**Development Application for 1 Alfred Street Sydney NSW 2000 (D/2016/1529) (SSD 8111)
Response to Submissions**

Marg Prendergast 30.3.17
Coordinator General
CBD Coordination Office

Figure 25 – Technical Details of Porte Cochere Design

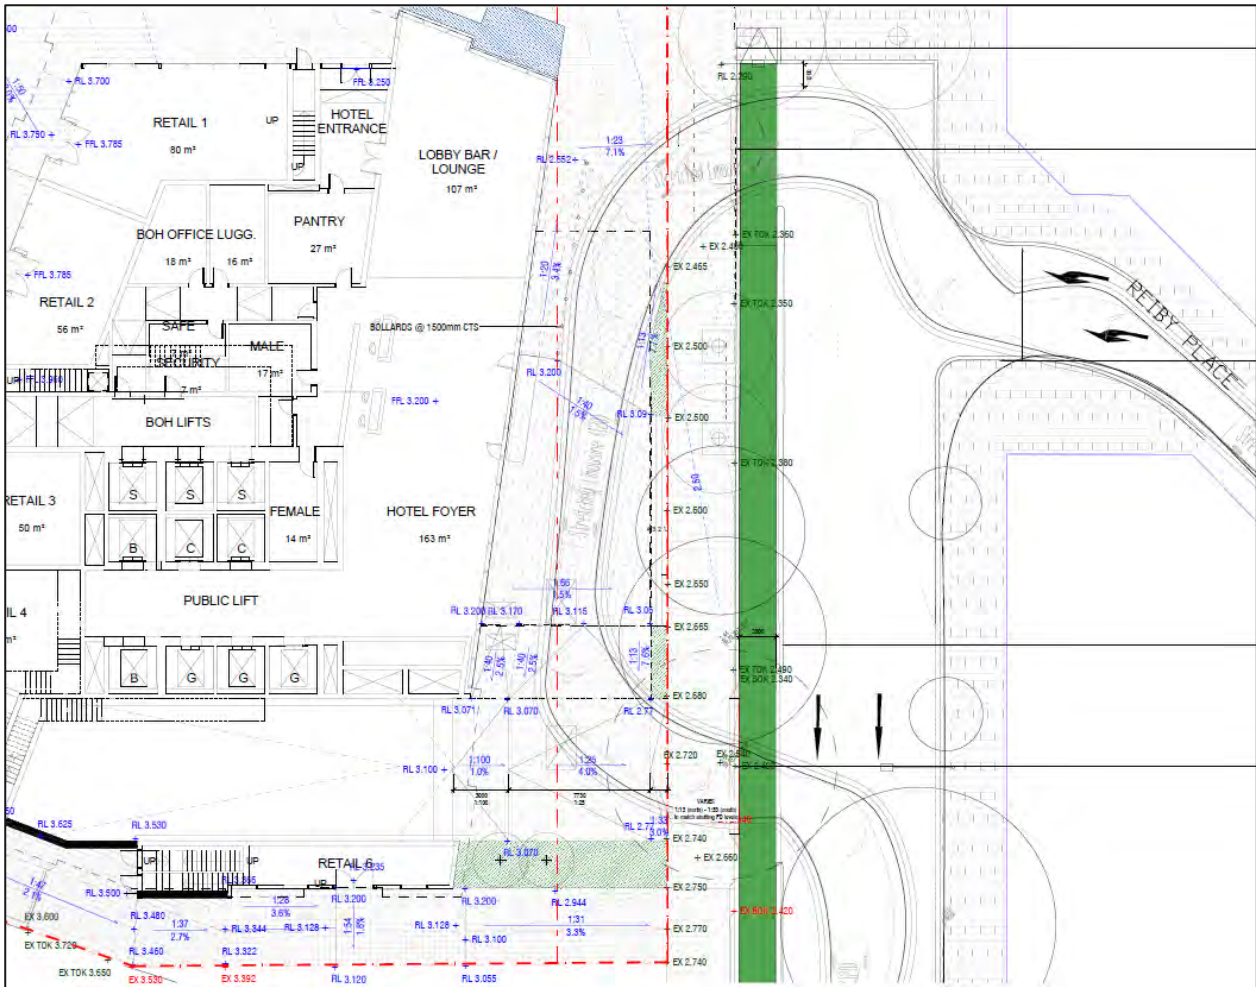
The Response to Submissions states that at the meeting held on 6 March 2017, TfNSW confirmed that the current design of the Porte Cochere is appropriate and does not conflict with the current road designs for Pitt Street being investigated by TfNSW.

- The final design for the Sydney Light Rail public domain, and its interface with the Wanda One site, is subject to ongoing refinement; and
- Based on the current state of the Sydney Light Rail design and the design for Wanda One, TfNSW provides its in principle support for the proposed Porte Cochere and northern crossover location. This in principle support is subject to ongoing collaboration between the Wanda One team, the CBD Coordination Office and the Sydney Light Rail Office as the detailed design progresses.

The Porte Cochere detailed design shall be undertaken in consultation with the CBD Coordination Office and the Sydney Light Rail Office within TfNSW. The final Porte Cochere Design shall be endorsed by the CBD Coordination Office within TfNSW."
